Re Development at the Old Garage Site, Dunsop Bridge
planning approval ref: 3/2022/0082

Please find enclosed on behalf of our client, The Duchy of Lancaster, a variation of condition planning application in respect to the original planning approval ref 3/2022/0082 for the redevelopment at the Old Garage Site, Dunsop Bridge.

For clarity we confirm that the following amendments have been incorporated into the enclosed revised drawings:-

Drawing title
PROPOSED PLANS

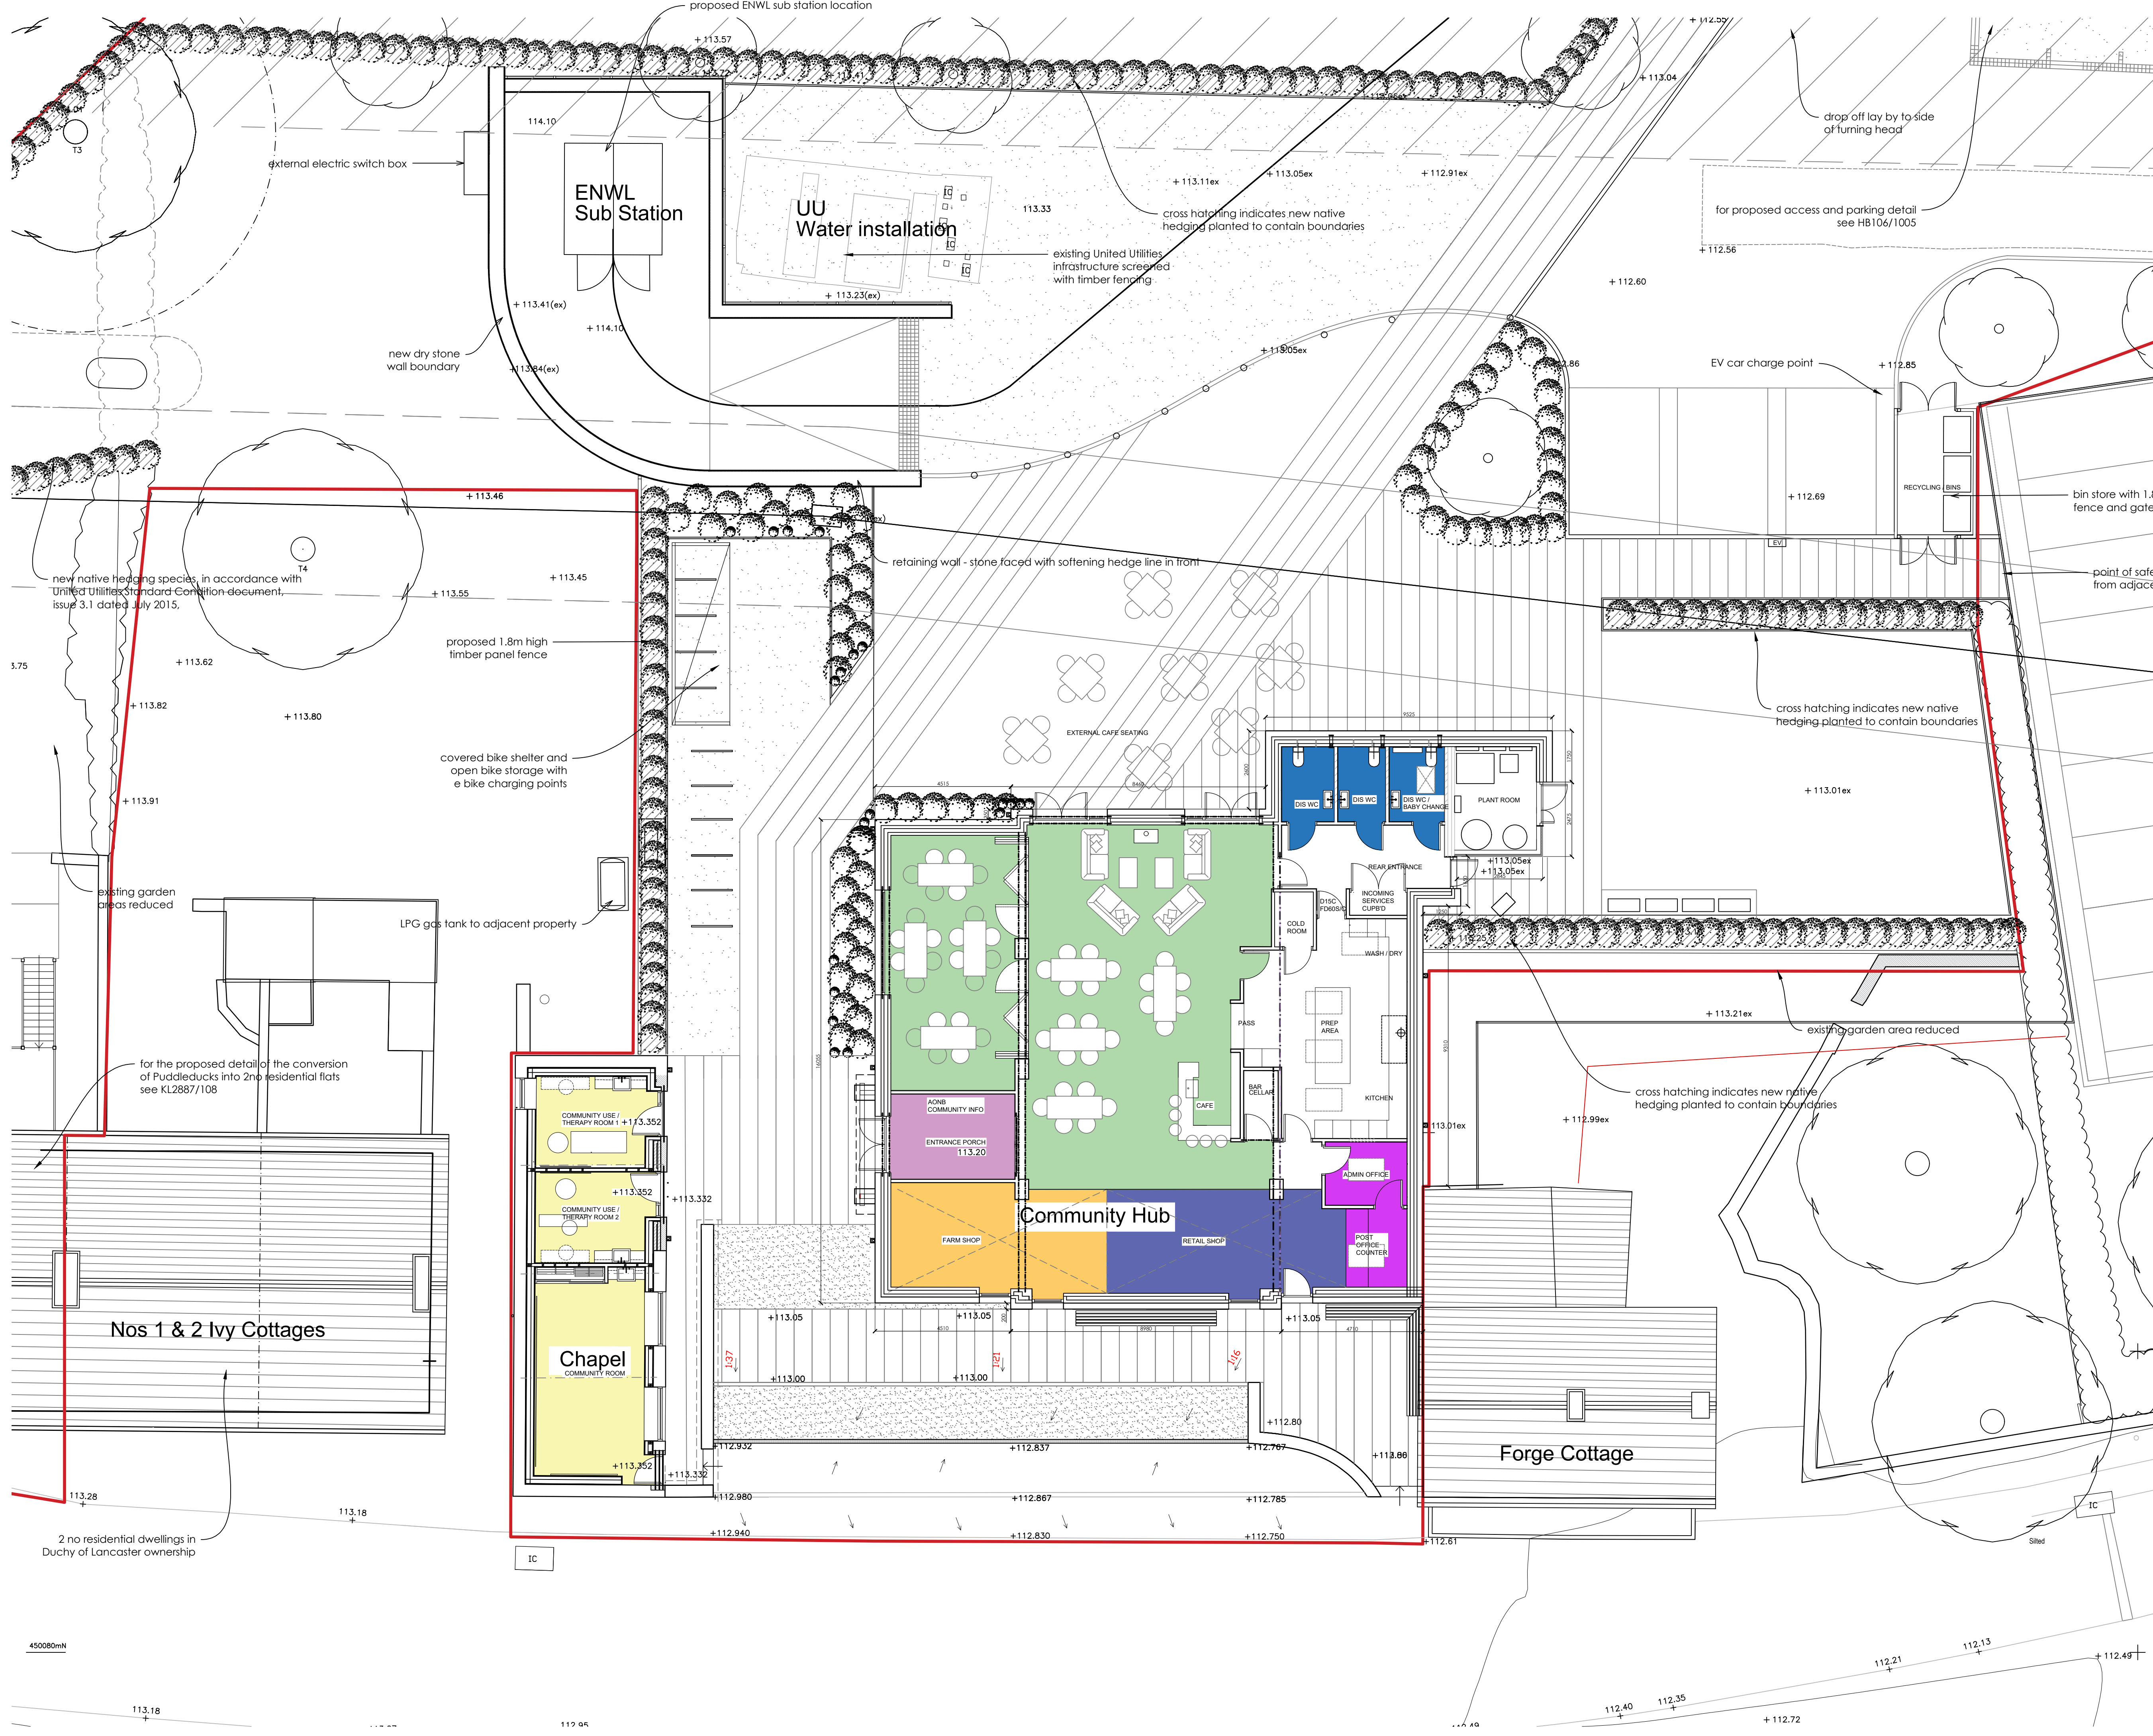
- All windows and doors are to be prefinished timber (accoya) with fenestration sub division as detailed on the submitted elevation detail.
- The previously approved detached plant room / storage area has been omitted from this updated application and a small extension to the side of the WC's incorporated to allow for a small plant room which forms part of the hub building.

- The elevated overhang to the north face of the previously approved WC building has been omitted, simplifying the proposed detail.
- The approved ground source heating and boreholes have been replaced with air source heat pumps which will be positioned to the back of the new fence line to Forge Cottage, adjacent to the plant room area.

Client	THE DUCHY OF LANCASTER		
Contract	THE OLD GARAGE SITE DUNSOP BRIDGE		
Drawing title	PROPOSED ELEVATIONS		
Scale	Job No.	Drg No.	
1:100	HB106	1007

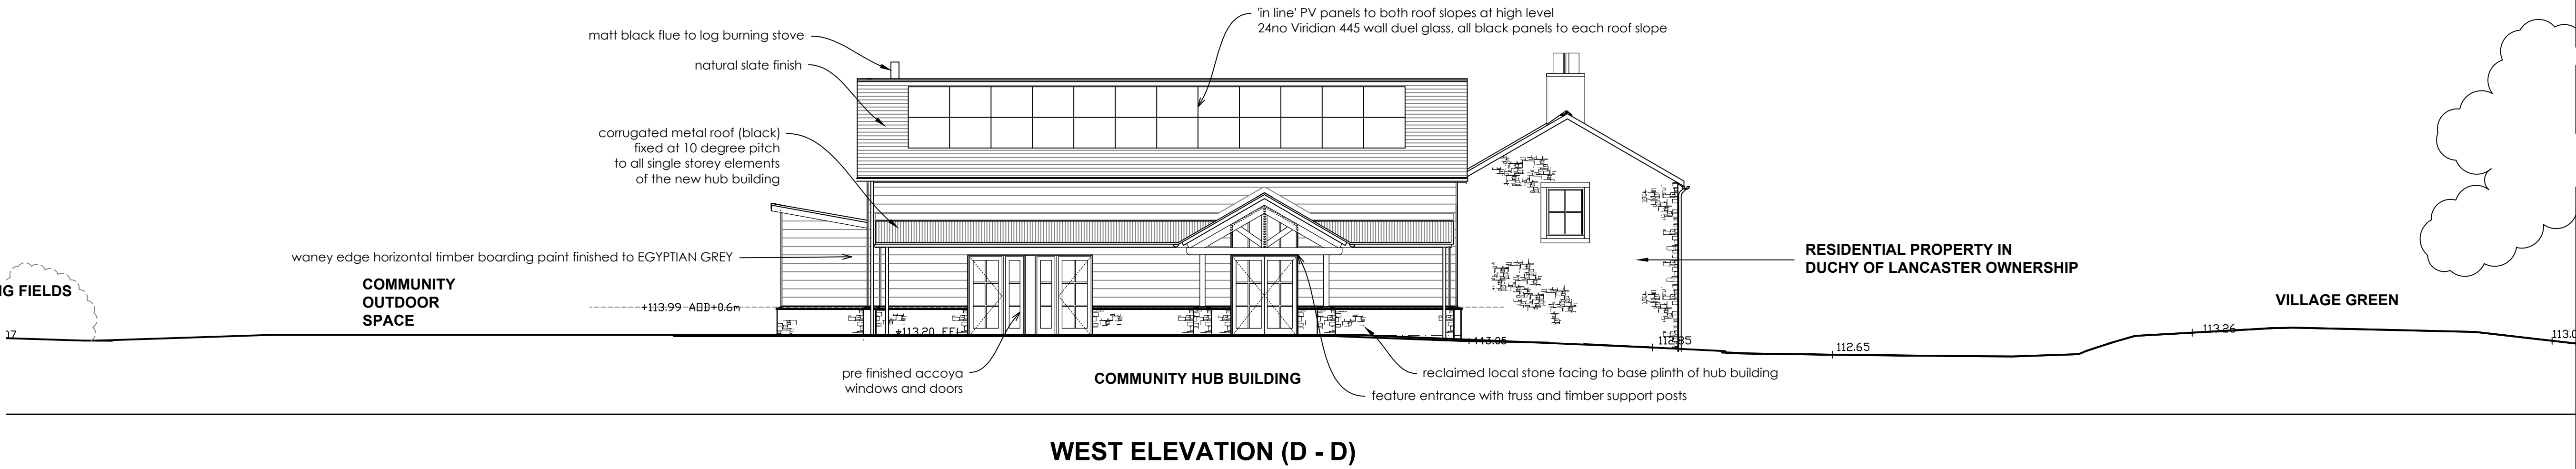
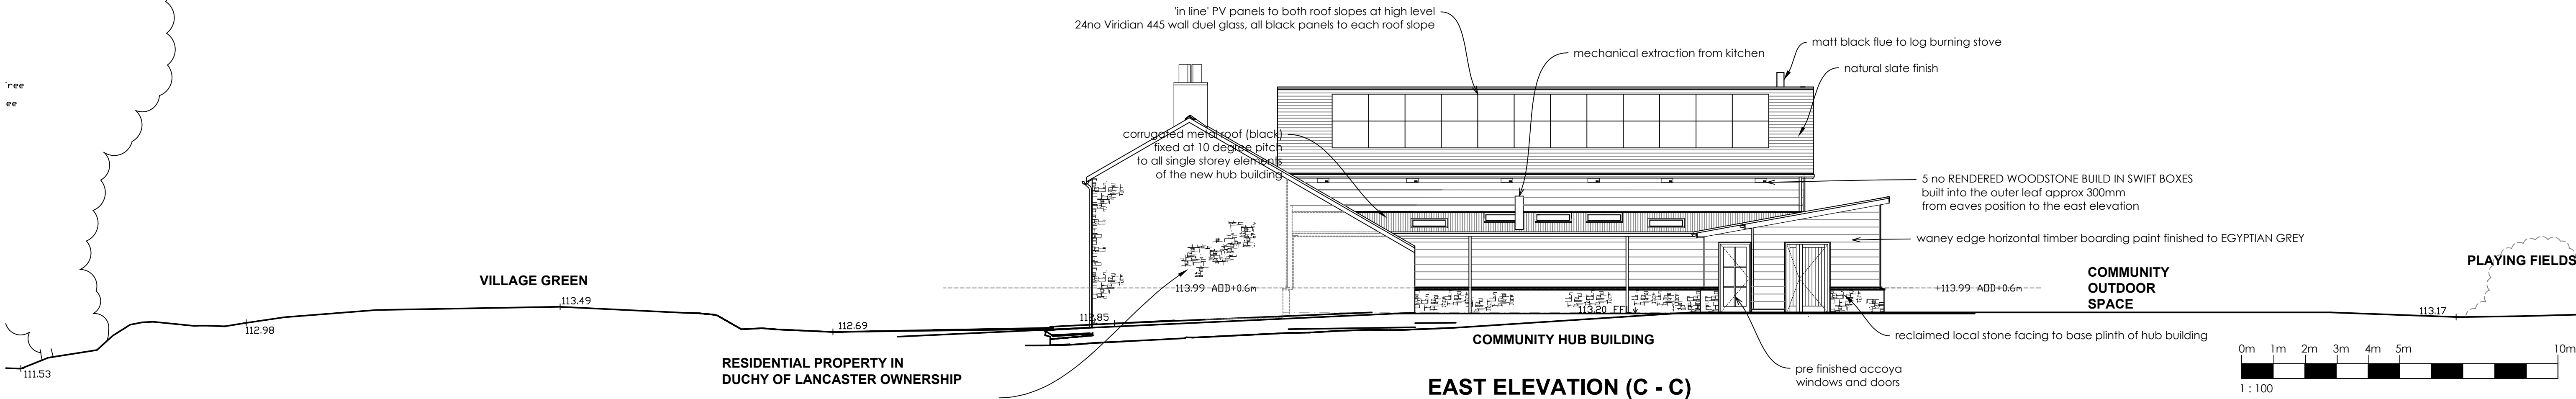
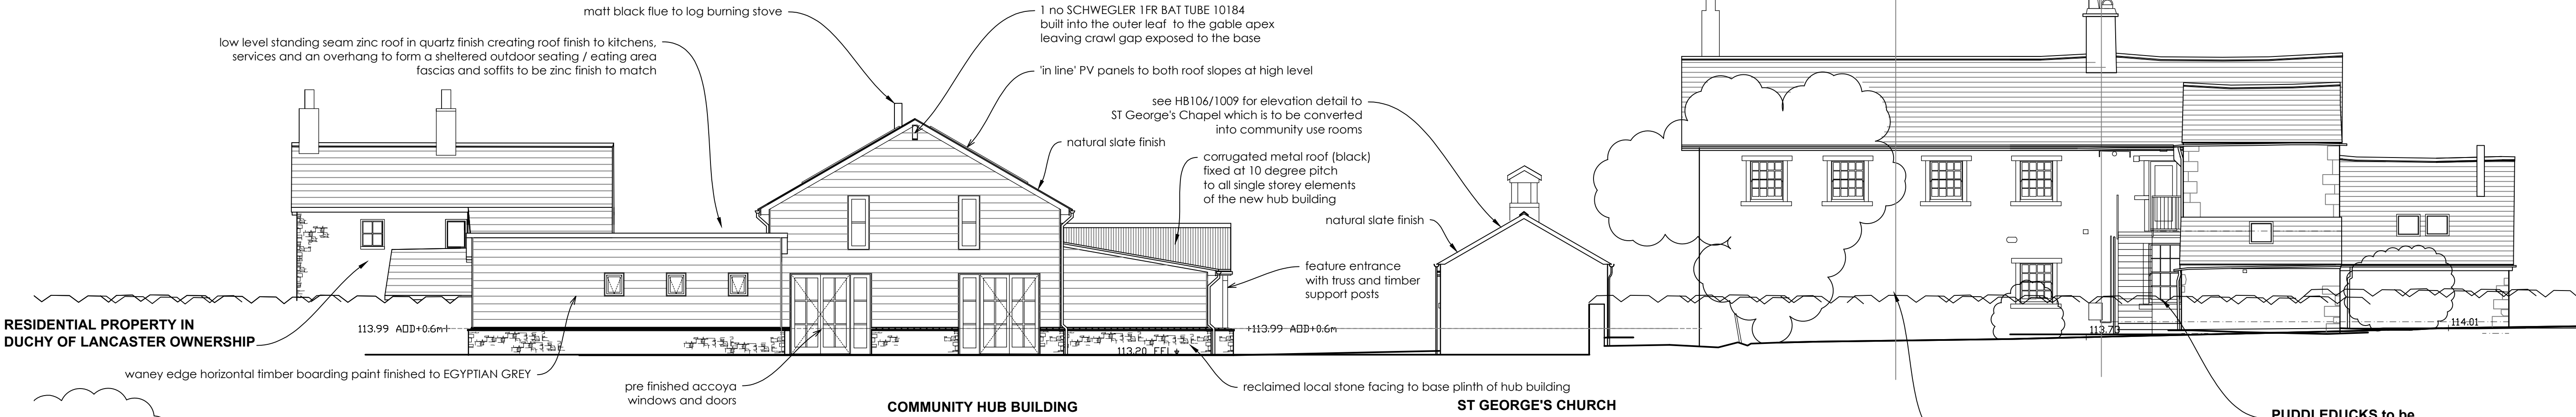
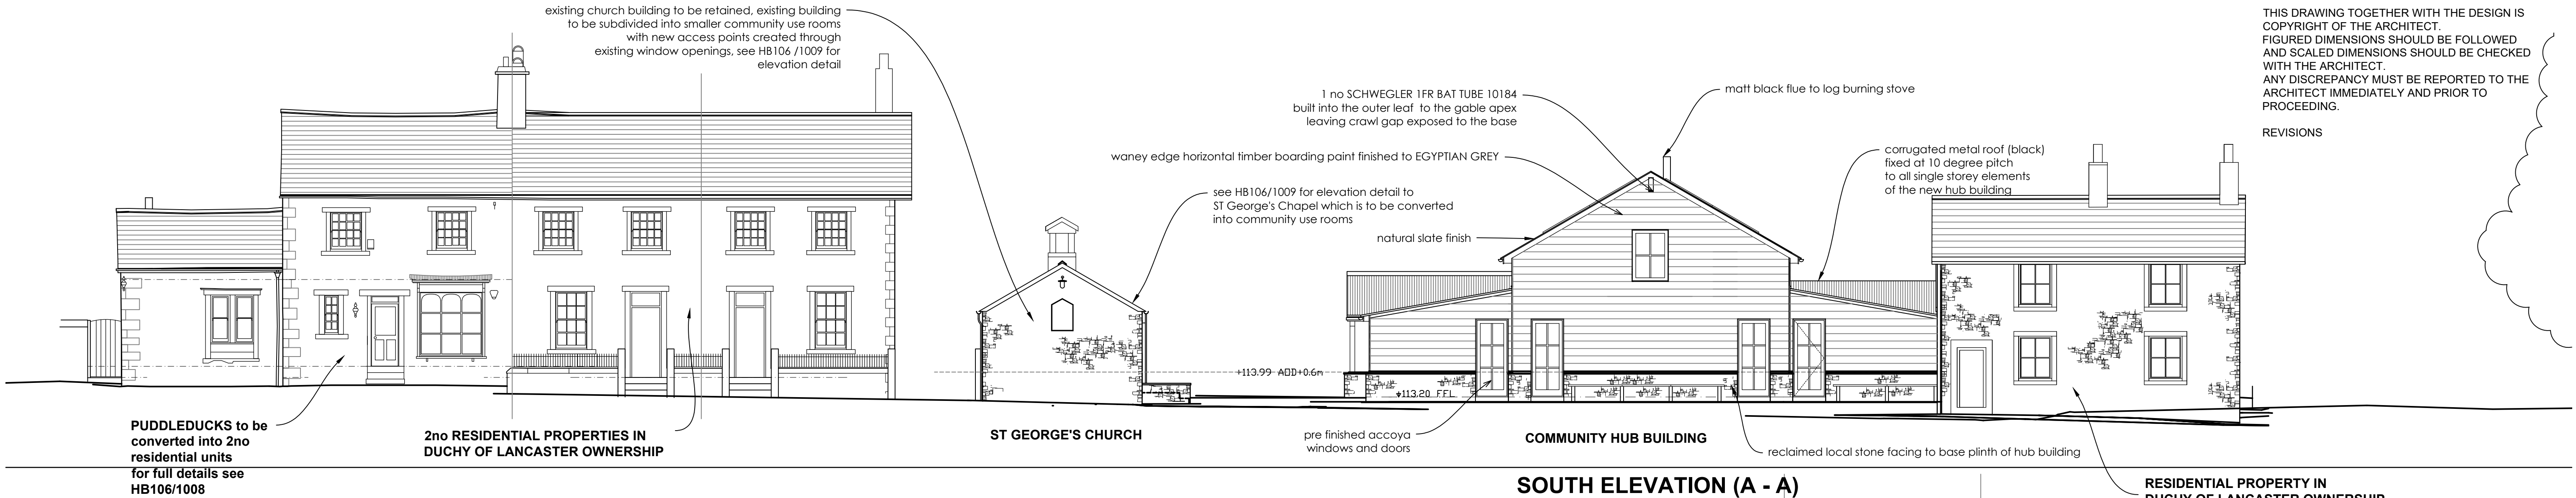
- The overall height of the hub building has been reduced together with the level and pitch of the proposed roofs to the single storey wrap around elements.

- The roof to the double storey height of the hub is to be finished with reclaimed natural blue grey slate which the Duchy have in storage, recently removed from a project at Lancaster Castle. Within the roof construction detail, both slopes of the main double storey building will include "in line" photovoltaic panels, 24no Viridian 445 watt, dual glass, all black panels to each side of the roof (48no in total). These panels will generate electricity which will be stored in 5no GIV energy 3.4 kW H/V stackable lithium batteries (17kw installed capacity). This is estimated to provide 15,122 kWh's/yr of the estimated annual building requirements of 25,000 kWh's/yr. Full details of the panels are enclosed as part of the application information. Note: these PV panels replace those previously approved on the lower zinc roof over the WC's.

- The lower level wrap around roofs are presented with a corrugated metal sheet finish in black. This replaced the approved zinc standing seam roof to the kitchen and WC's but extends the detail to the west elevation. Details of corrugated metal sheet are enclosed as part of the application detail.

- The previously approved link roof from the hub to the existing chapel has been omitted as it is felt that the simplicity of the two separate buildings is more appropriate to Dunsop Bridge. A formal entrance to the hub has been introduced with a simple roof detail and feature timber truss and post detail to the west elevation as indicated. The timber will all be for a paint finish to match the window / door frame colour.

- The external material finish to the hub building has been amended to reflect a more rural / barn solution. The proposed detail retains the stone base plinth and a cut stone cill, but above this cill detail, the building will be finished with horizontal boarding. The boarding will feature a feather edge boarding that has a concealed tongue and groove joint to ensure a positive fixing / connection and will feature a waney bottom edge to all the boards. The horizontal timber boarding is to be paint finished in "Egyptian Grey", samples and details of the boarding and specified colour are included within this application.

- The chimney stack to the south elevation has been omitted and a log burning stove and flue have been incorporated to the north elevation. This now allows for a stove to be incorporated within the hub, creating a welcoming feature.

- Overhanging eaves and verges have been introduced to the hub building to provide an overhang and shadow line to match the surrounding properties. This gives a better strength detail to the roofs and adds local distinctiveness and character.
